From: Tim Screen
Sent: 14 September 2022 11:26
To: Andy Bateson
Cc: Julie Baxter

Subject: 22/00959/REM - OS Parcel 9100 Adjoining And East Of Last House Adjoining And North Of, Berry Hill Road, Adderbury

Section through Attenuation Basin

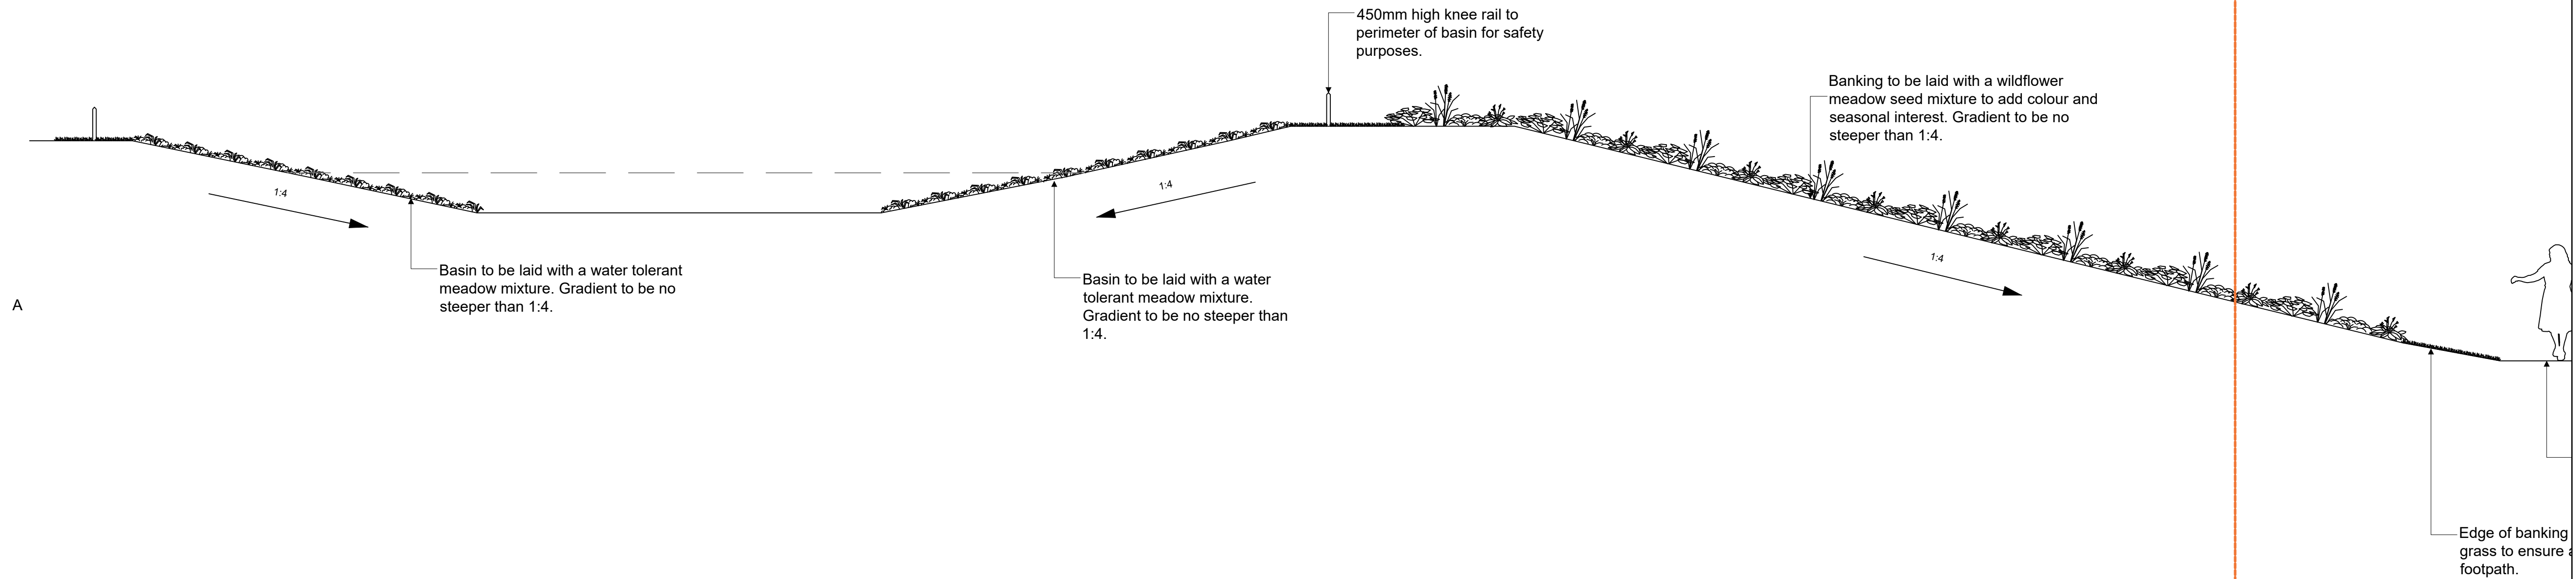
The Basin Section indicates the 1:4 gradient where precipitation will possibly cause the play area to become quite wet and muddy. The toe of the gradient may require a catch drain to prevent to alleviate this problem.
